Description: Change of use from doctor's practice to 7no. apartment and 1no. studio flat including external extensions and alterations to building.

Site Address: Caxton House Surgery, 53 High Street, Grimethorpe, Barnsley, S72 7BB.

0m 1m 2m 3m 4m 5m			
Rev.	Description	By	Date
Project 53 High Street Grimethorpe Barnsley			
S72 7BB			
Drawing Title Proposed Floor Plans			
Drawing No. High/03	Rev.	Drawn by J.S.	Scale 1:50@A1
		Date Jul '22

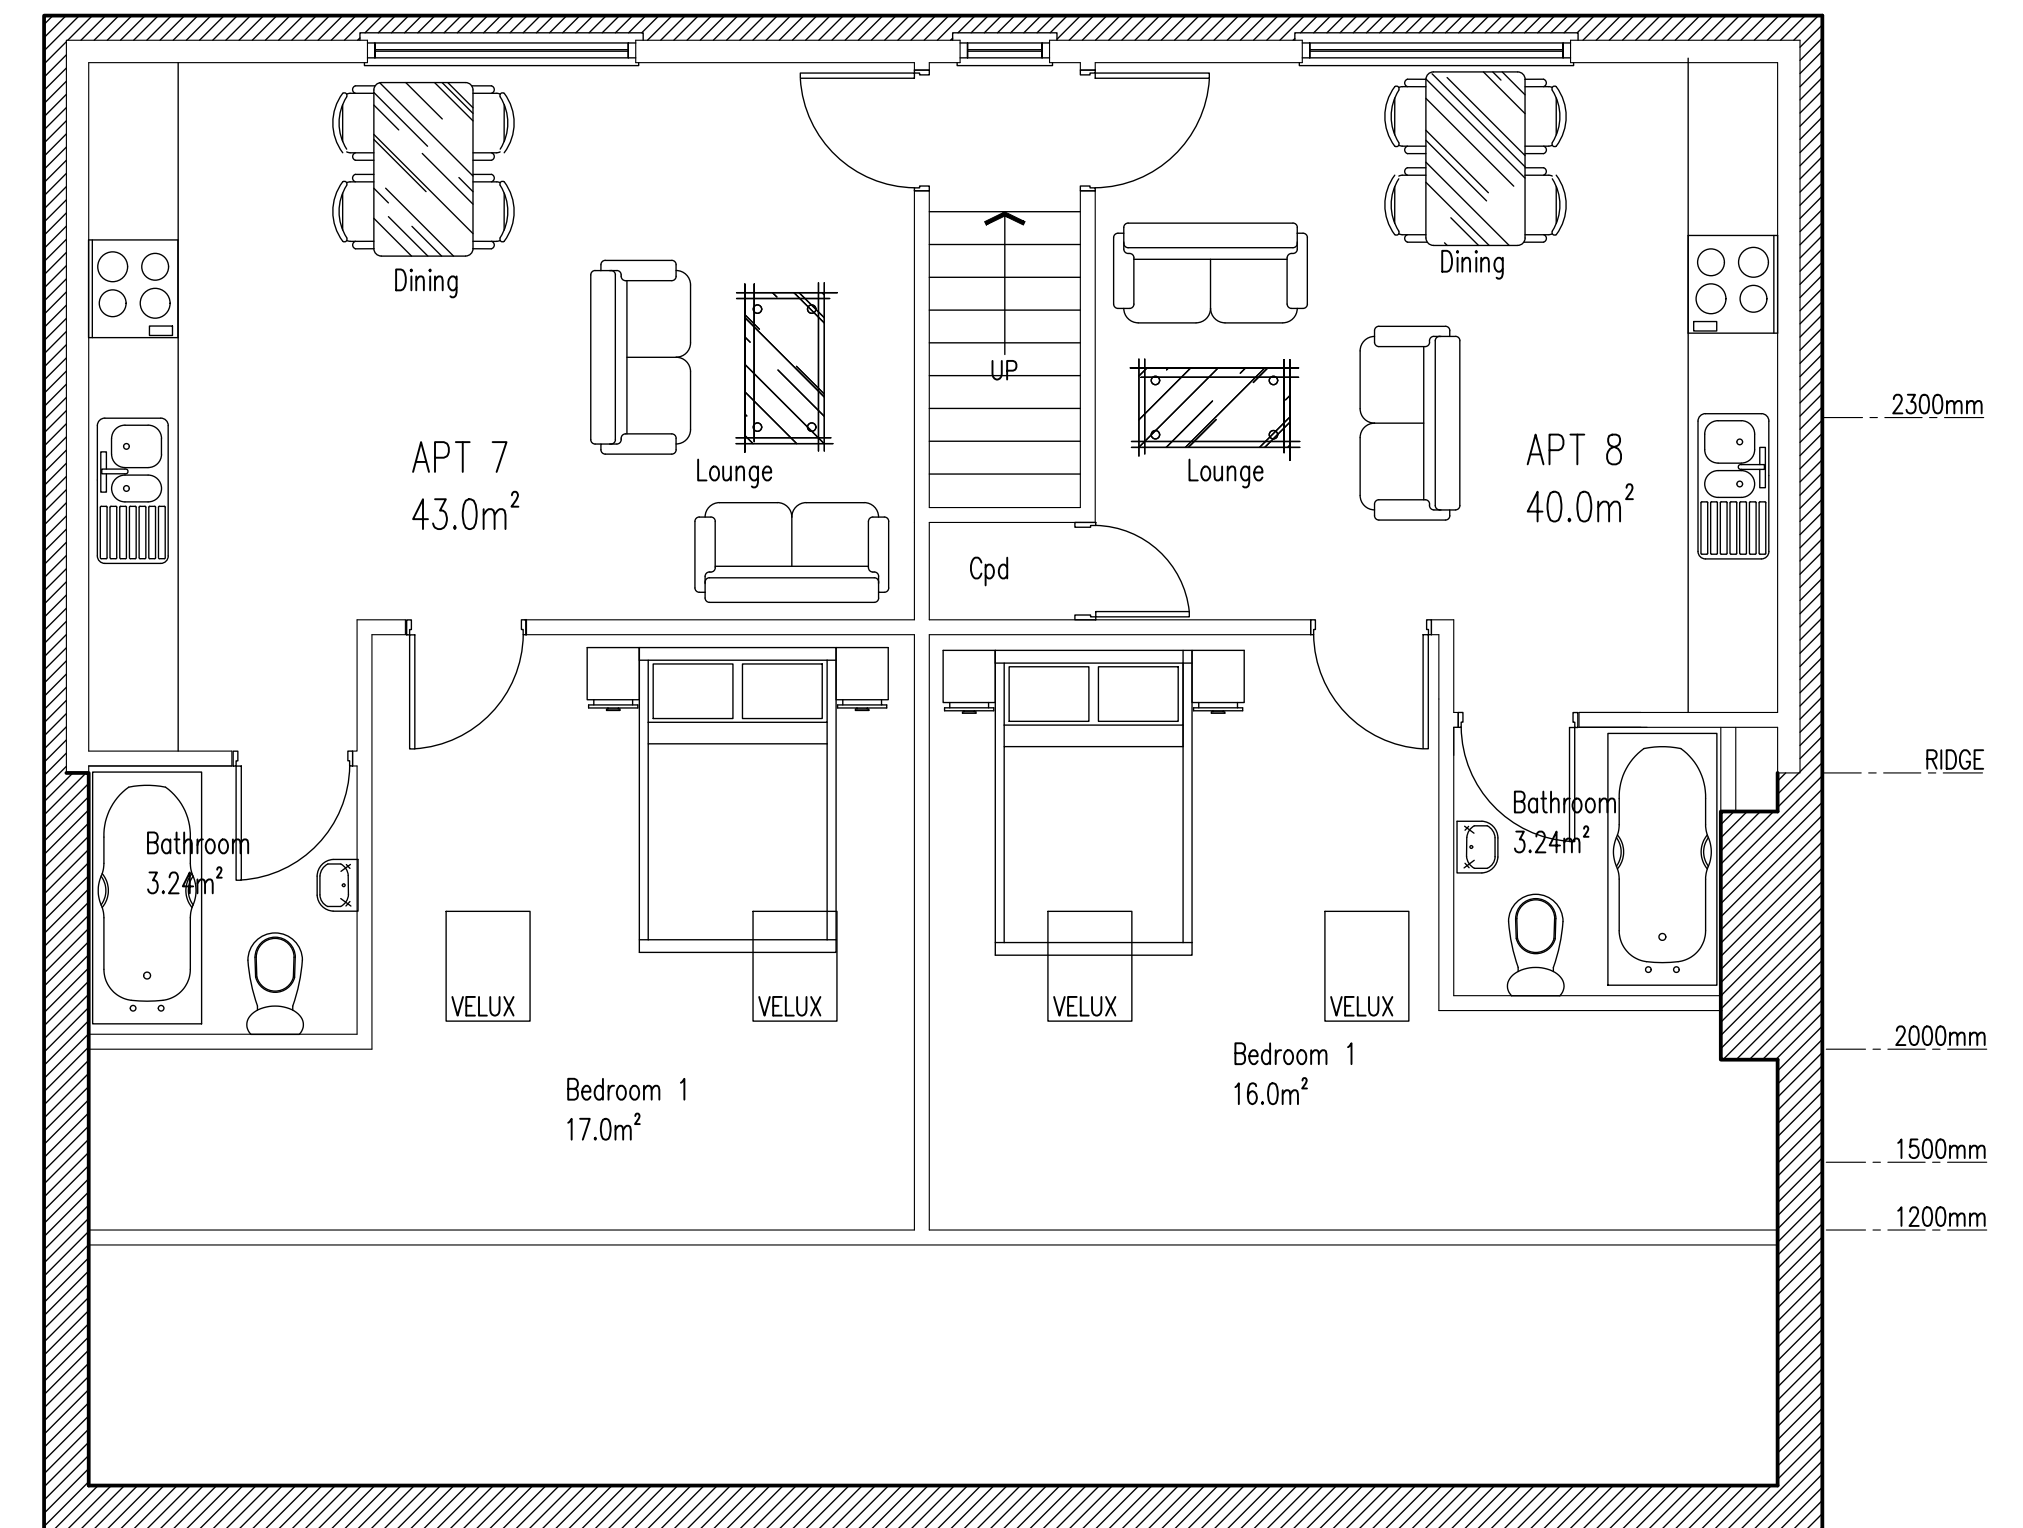
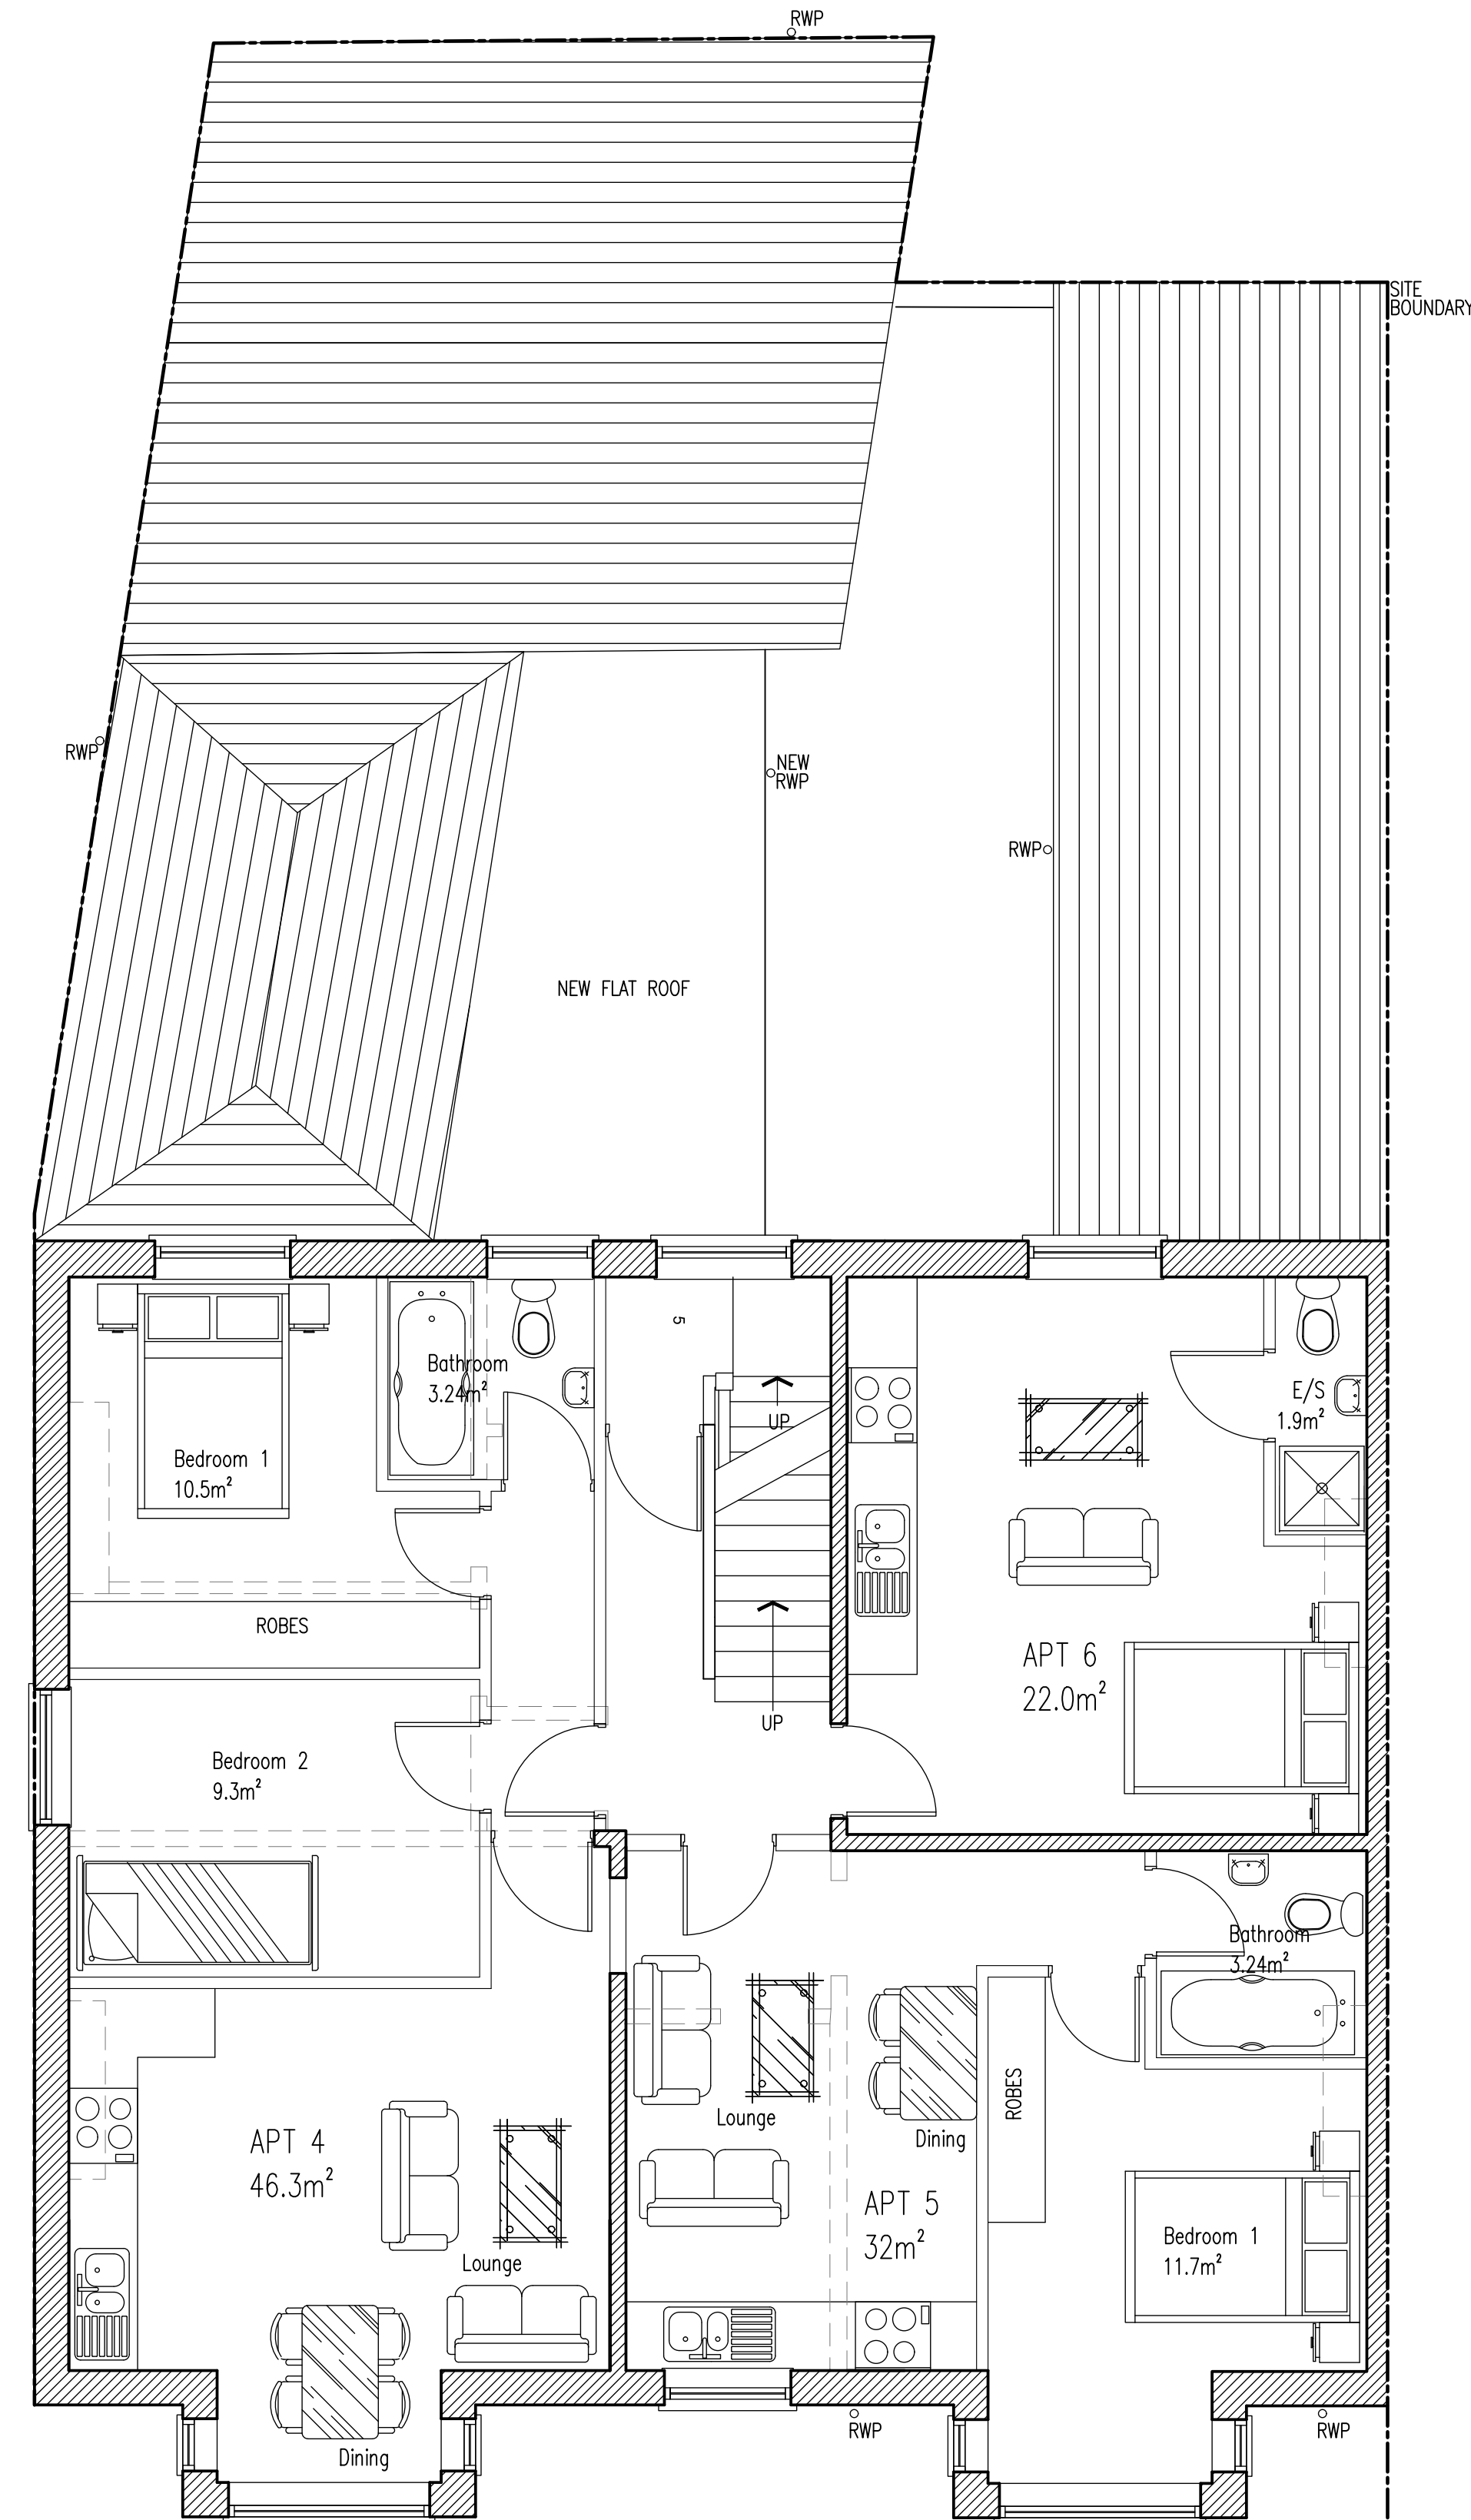
The double bedroom in apartment 1 at 10sqm has a shortfall of 2sqm, the open plan/ combined kitchen/diner/lounge (KDL) falls short at 16.08sqm compared to the standard of 27sqm and the bathroom falls short at 3.24sqm compared to the standard of 3.5sqm, with the overall apartment being substandard at 40.55sqm, falling short of the 62sqm standard for a 2 bed, 3 person apartment. The combined KDL in apartment 2 falls short at just 20.5sqm and the bathroom again falls short, although the apartment achieves an overall floor area of 65.8sqm which would comply with the standard for a 2 bed 3 person apartment. Apartment 3's KDL falls short at 21sqm, the bathroom again falls short and there is an overall shortfall in overall floor area at 56.1sqm for a 2 bed, 3 person apartment. The double bedroom in apartment 4 falls short by 1.5sqm, the bathroom and KDL are substandard at 3.24sqm and 18.39sqm, in addition to the overall floor area at 46.3sqm for a 2 bed, 3 person apartment. The double bedroom, bathroom and KDL in apartment 5 fall short at 11.7sqm and 13.66sqm and 3.24 and the overall floor area is substandard at 32sqm instead of 46sqm for a 1 bed, 1 person flat. Apartment 6 is a 1-bedroom studio flat with a substandard bathroom at 1.9sqm and an overall incompliance to the standards at 22sqm for total floor space instead of 33sqm. Apartment 7 has a substandard bathroom and KDL at 3.24sqm and 21.7sqm and the overall floor space does not comply at 43sqm for a 1 bed, 1 person flat. Alike apartment 7, apartment 8 does not comply with any of the standards with a bathroom of 3.24sqm, a KDL of 18.74sqm and an overall floor space of 40sqm for a 1 bed, 1 person flat.

In addition to the above, it is considered that the outlook and availability of light for future occupiers is substandard in some of the apartments. Bedroom 2 of apartment 1 is not served by a window and thus would not receive any light nor have any outlook; apartment 6 (the studio flat) is a single aspect flat and would be served by a single small window which would not ensure an adequate amount of light or outlook and the bedrooms of apartments 7 and 8 are not served by a window and only small velux rooflights which again would not be sufficient outlook nor allow for sufficient light for a 1 bedroom, 1 person flat.
